ASSESSMENT REPORT

Section 75W Modification Riveroaks Residential Subdivision, Ballina Local Government Area MP 06_0118 MOD3

STAGING LAYOUT PLAN

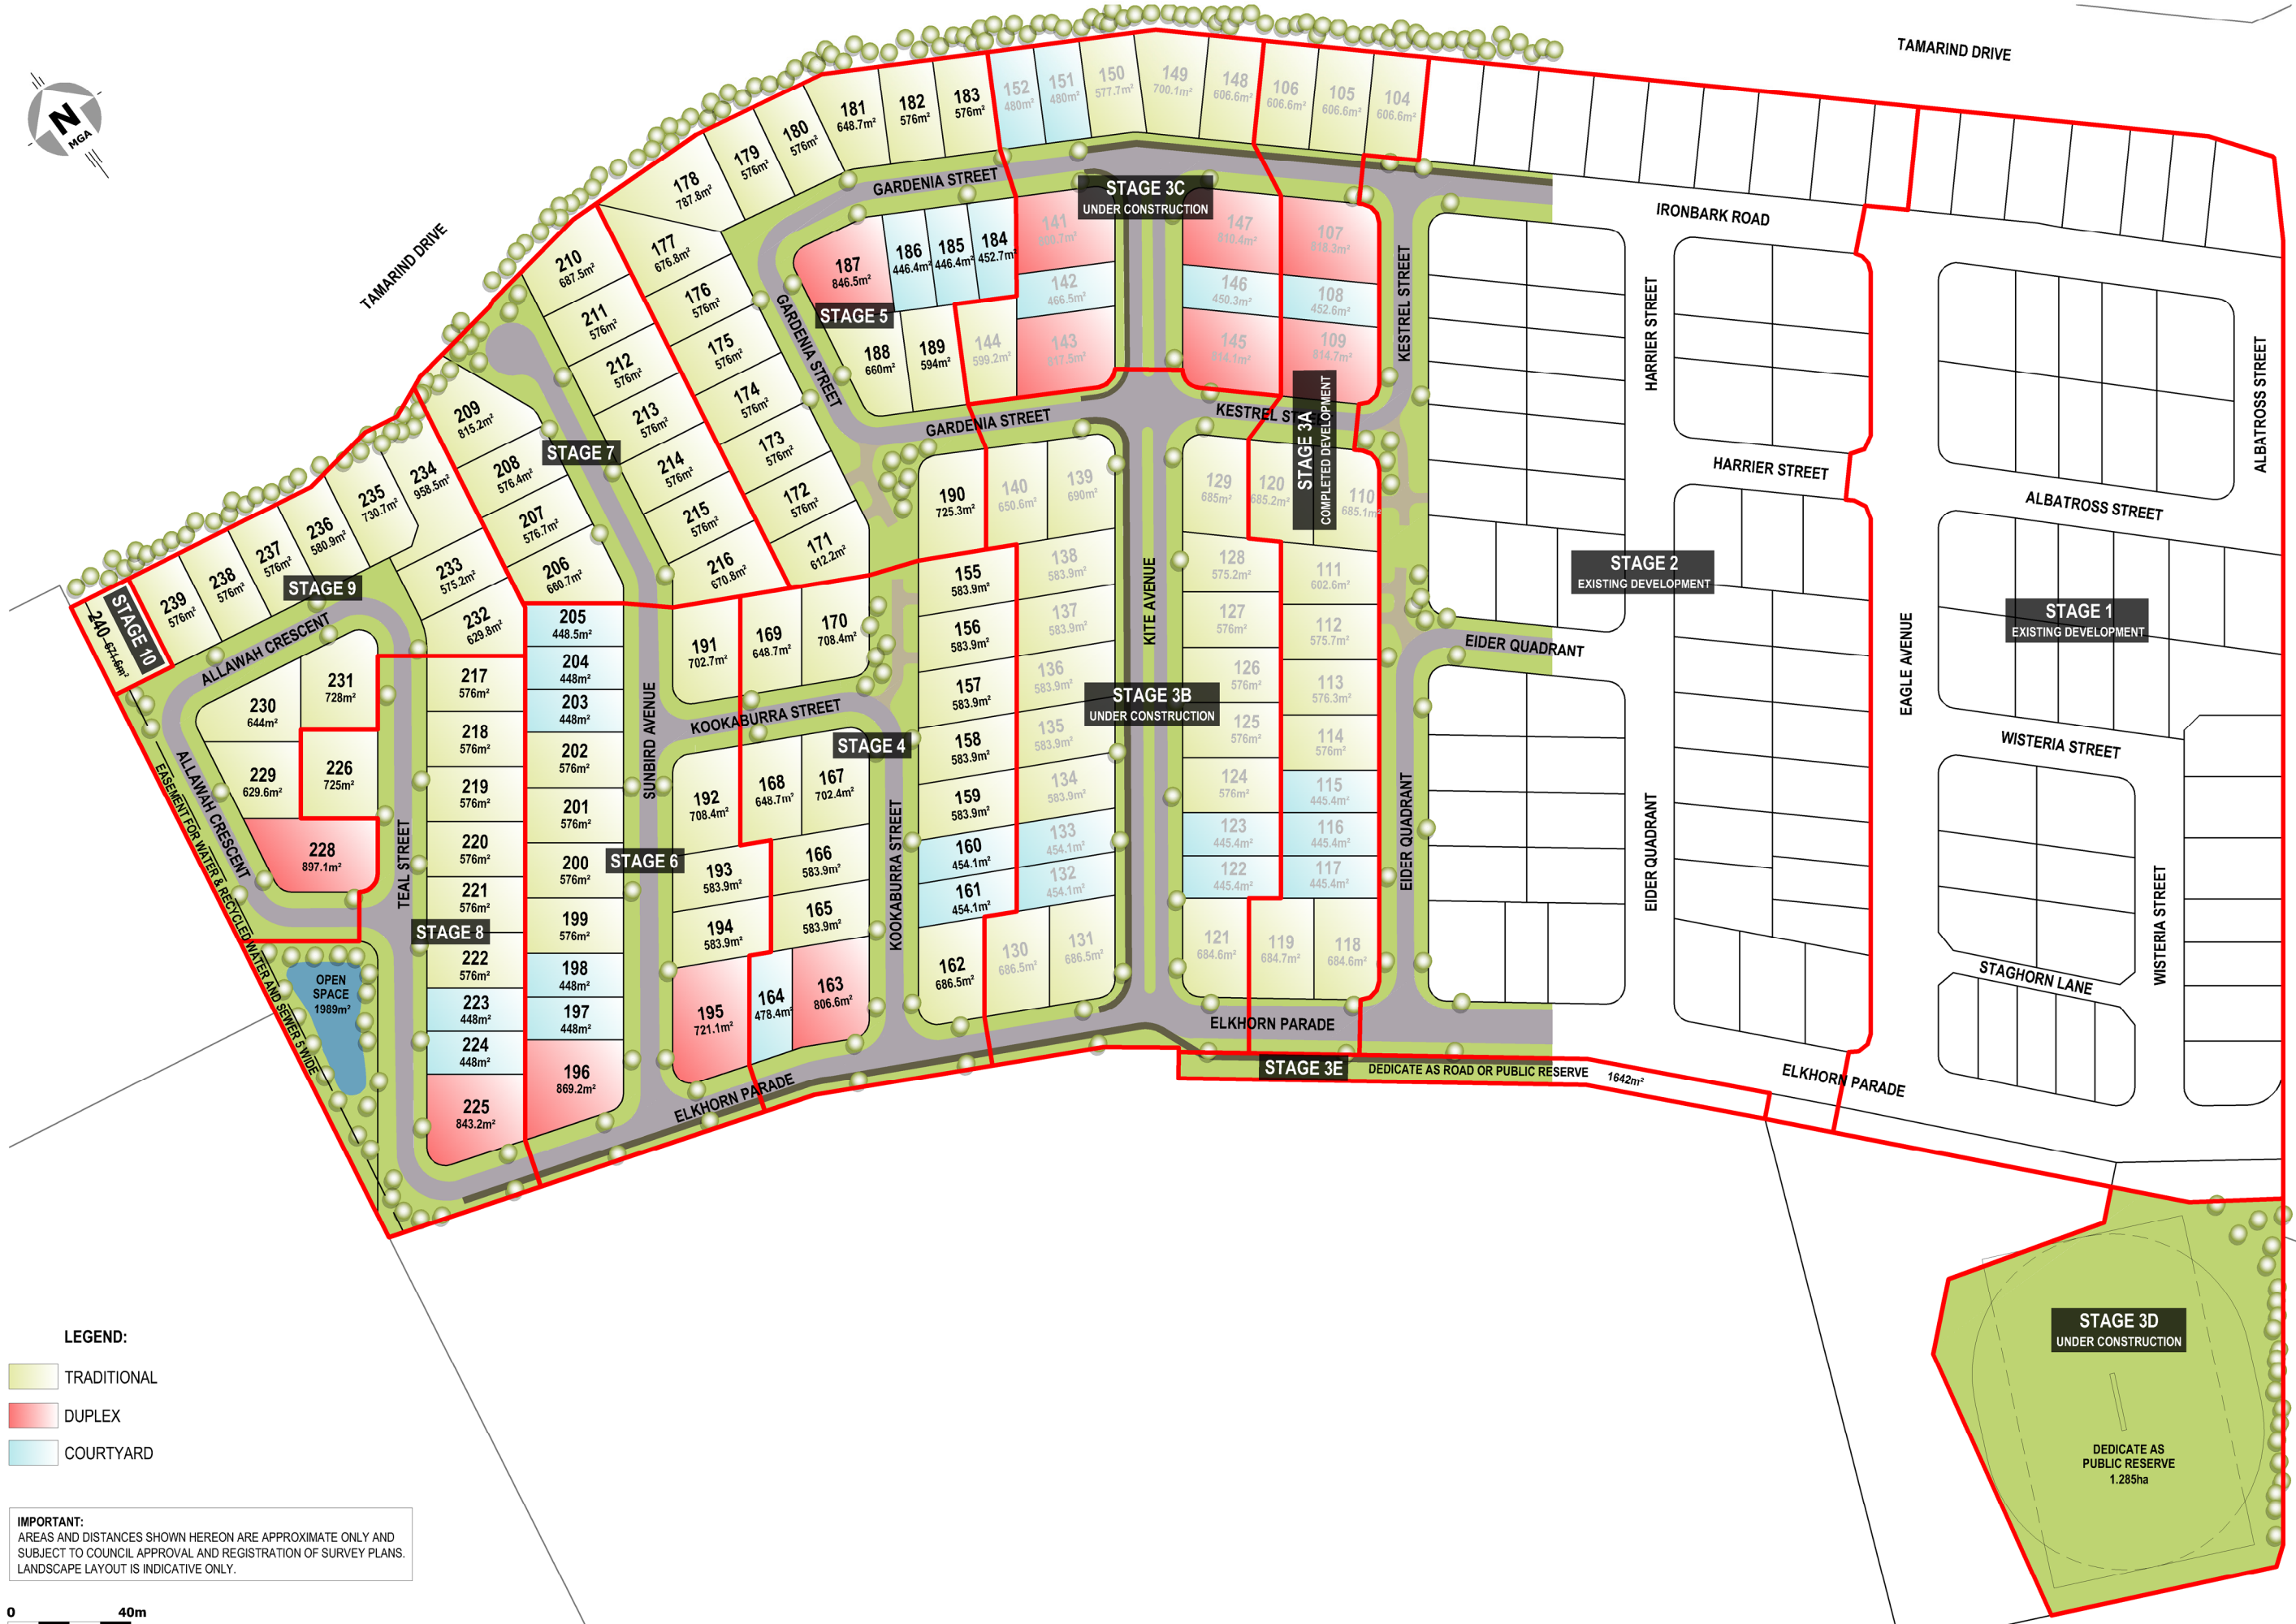
However, the Department is concerned with the proposed final stage (Stage 10) of the development, which consists of a single allotment, lot 240 in the north-west corner of the site, refer to **Figure 4** below.

However, the Department considers that isolating the lot as a separate final stage may restrict the resolution of the issues associated with the allotment if Stage 9 is already developed. In order to resolve issues with the suitability of the allotment, it may be necessary to make a boundary adjustment, either resulting in deletion of the allotment (with adjoining lots in Stage 9 increasing in size); or increasing the size of the allotment (by reducing the size of adjoining lots in Stage 9). It is therefore considered that Lot 240 / Stage 10 should be developed in conjunction with Stage 9 to ensure there is an opportunity to resolve any outstanding issues as necessary. Conditions to this effect have therefore been included in the recommended instrument.

Subject to Stage 10 being developed in conjunction with Stage 9, the Department considers that no adverse impacts would arise from developing the site in smaller stages as proposed.
